Project Name: DOUGHERTY FLD. IMPROV.
Address: 91 Douglass St **CBL:** 066 - A-002-001

Project Description: Dougherty Field Improvements Phase 1; Douglass/St. James Street;
City Of Portland, Applicant.
Zoning: ROS

Project Name: Dougherty Field Improvements Phase 1
City of Portland, Applicant.
Project ID: 10-79900030 **CBL:** 066-A-002-001
Project Address: Douglas Street/ St. James Street
Planner: Jean Fraser

The Dougherty Field Improvements Phase 1 are detailed in the approved plans as submitted by the applicant and prepared by Woodard & Curran: *Grading and Utility Plan* Sheet 2 11/09/2010; *Skate Park Area Grading and Drainage Plan* Sheet 3 11/09/2010; *Layout Plan* Sheet 4 11/09/2010; *Landscape Plan* Sheet 5 10/12/2010; *Details - 1* Sheet 6 10/12/2010; *Details - 2* Sheet 7 11/09/2010 and *Details - 3* Sheet 8 10/12/2010.

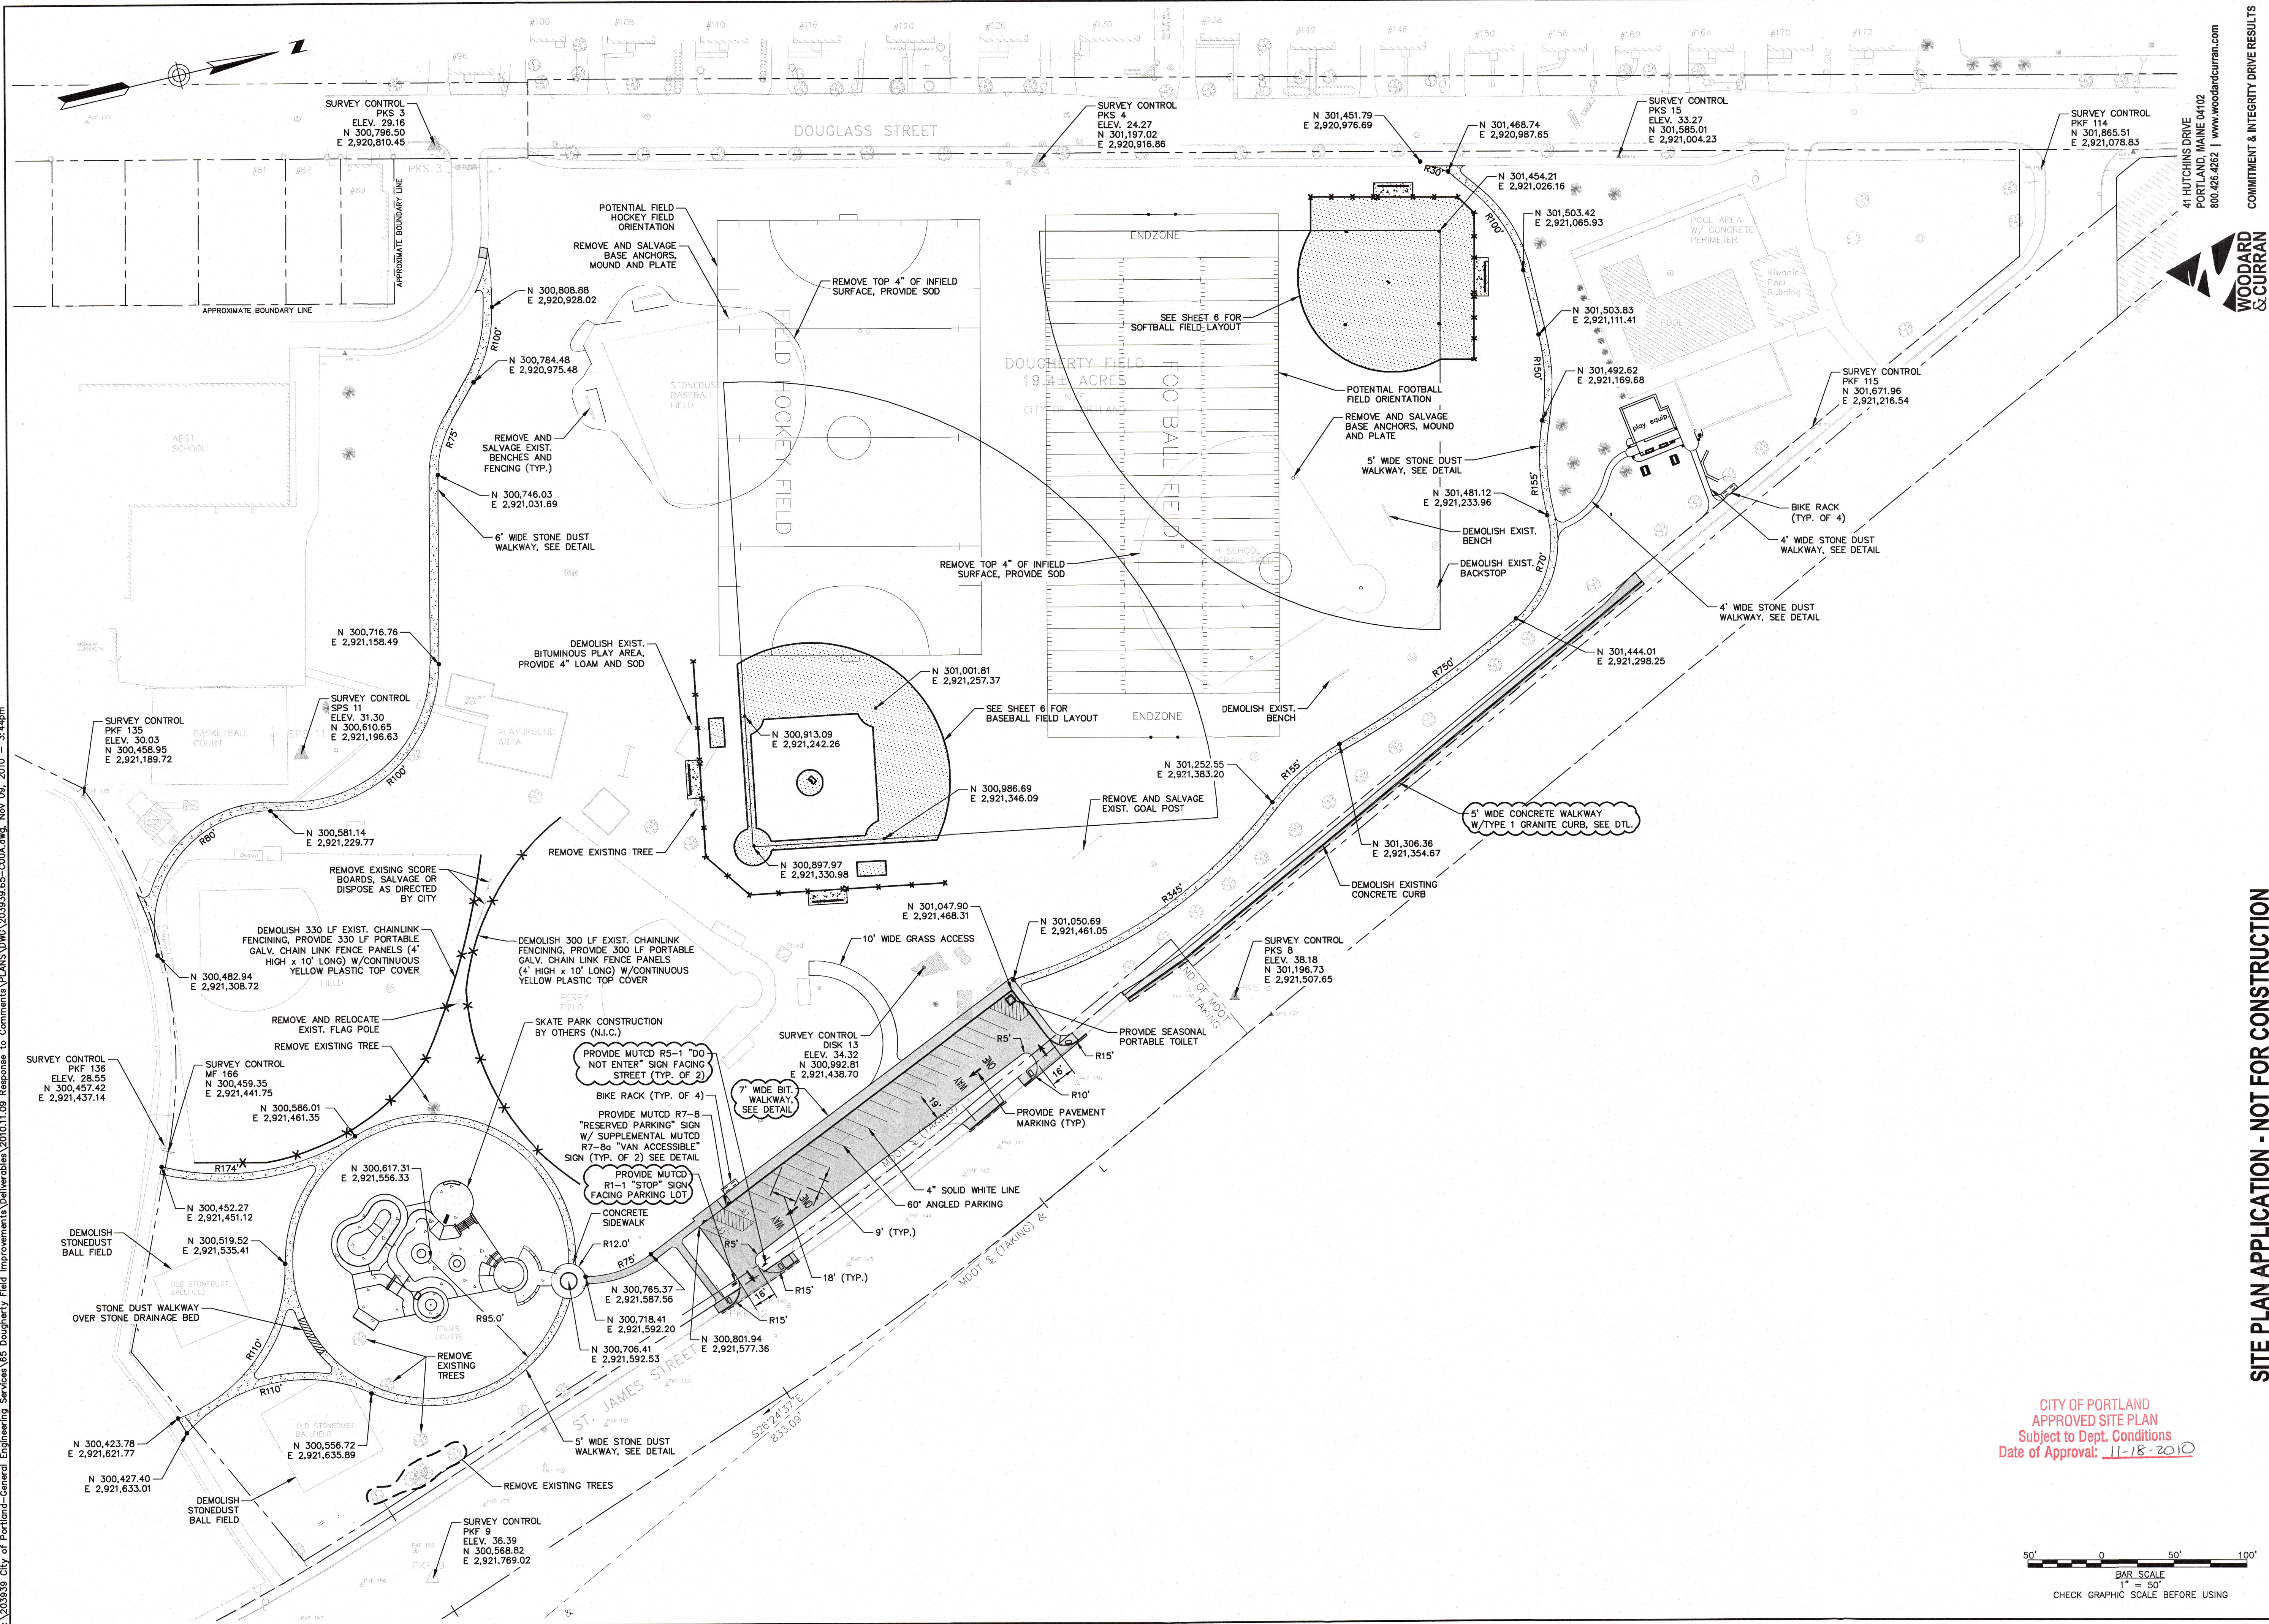
It has been brought to my attention that you do not want to implement a feature shown on the approved site plans (shown on 3 plans within the approved plan set, marked as "10' wide grass access" leading from the parking lot on St James towards the baseball diamonds).

We are happy to send that e-mail, but I just want to clarify- it was my understanding that this "walkway" (flatter width of grass with a more gentle slope) would create areas for easier viewing of the baseball diamonds (by sitting on the grass on the slope) and make it more accessible for people pushing baby buggies/pushchairs coming from the parking lot to watch a game. It seems to be quite purposeful in design. However, I understand you may feel this benefit is outweighed by the future mowing issues or the re-grading bringing it too near the baseball.

Please confirm or send a sketch of the revised grading and I will confirm re the site plan di minimus approval.

1) The 10' wide grass path from the parking lot down to the fields will just eliminated and the same smooth contour or slope all the way across will be applied. It looks better and functions better for maintenance. I don't want to encourage anyone to drive down there either. The sloped bank makes a very nice perch for families to sit and watch the games so I don't want to break that up.

1) No - the grass path down from the parking lot was a mistake from the beginning. But it kept showing up on the new and then the new and then the new drawings. From a maintenance, construction and functionality point of view it is useless. To keep the same taper and slope all across that plane from the parking lot down to the fields, will provide a pleasant seating area, easy grass growing and maintaining location with less contours to scalp and after talking with Jeff yesterday - a nice platform to install a few shade trees.
2) The main problem I see with the spit of grass between the parking lot and the sidewalk is maintenance and wasted parking space. Jeff and I designed a simple system for that edge after talking with Gordie and I will send that to you and Phil shortly. Basically you would have the parking lot go right to the sidewalk with several protective tree wells installed.

SITE PLANTINGS

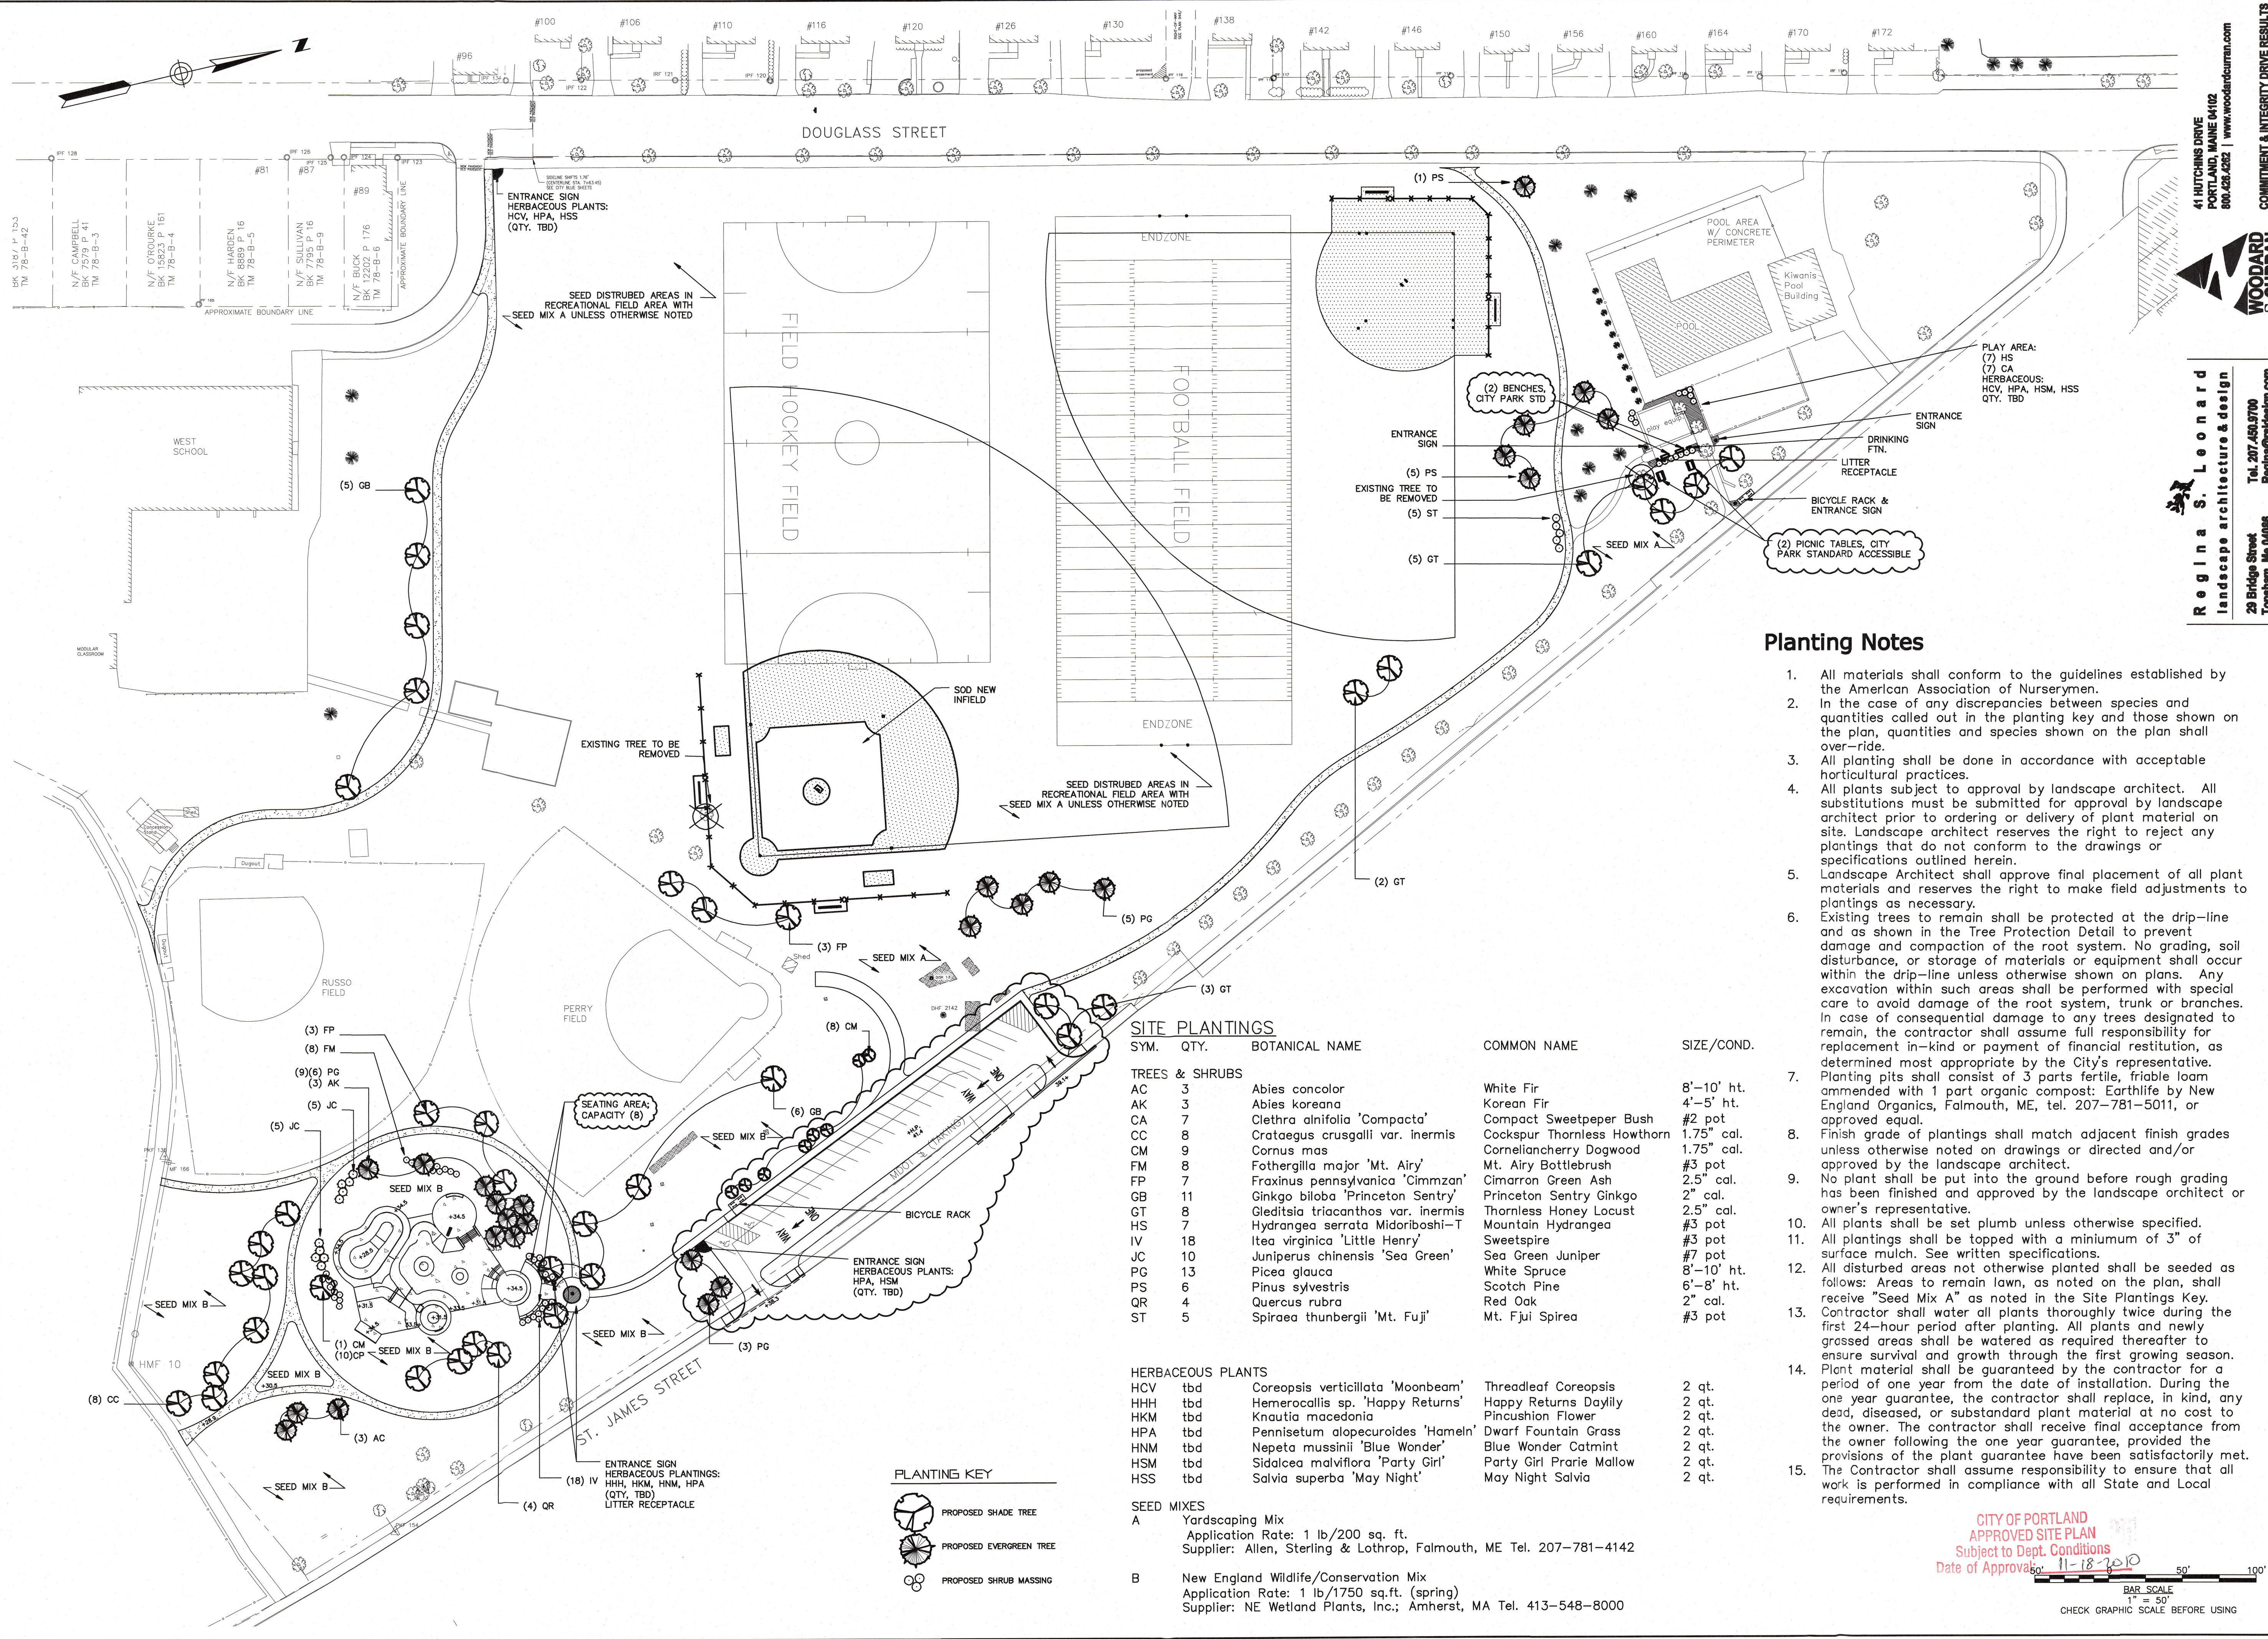
The proposed changes to the parking lot - (2) below are not "small" - they are quite substantial and cannot be dealt with by e-mails. Please do not proceed with any changes to the approved plans until you have submitted another (revised) plan and it has received formal approval.

We need a detailed plan (prepared by an engineer and to scale) that shows the revised parking layout, that it meets the city's technical standards (section 1- its on the city's website), indicates how the drainage will be revised, and shows the locations of trees and how they will protected if within a paved area. It should also show how pedestrians will be protected from cars ie there may need to be a guardrail alongside the sidewalk -- and there are other questions that must be clarified to ensure this meets safety and other site plan requirements (including re trees).

I don't believe that parallel parking along the side of the drive aisle will be allowed as it is not safe- but angled parking may work here (because its one way) and give more additional parking. If angled parking can fit here then islands at the ends/between the parking spaces could be introduced for some trees. You need to arrange for someone to do a scaled detailed drawing and get it sent to me by pdf.

Otherwise it may be best to leave the plan as is and add in the trees in the esplanade- I understand there is considerable street parking in this area.

My preference would be to have street-trees along the parking lot between the street and parking area. Ideal spacing would be roughly 45'. This would continue the existing tree line that starts at Douglas Street to the Skatepark. These trees would help screen the industrial / commercial use across the street to the existing residential homes on Douglas Street.

While I do see the value in the added parking spaces for this busy site, street-trees should be included in this plan. Currently I do not have a copy of the original landscape plan, so I would refer to the landscape plan as approved or to add street trees into any changes.
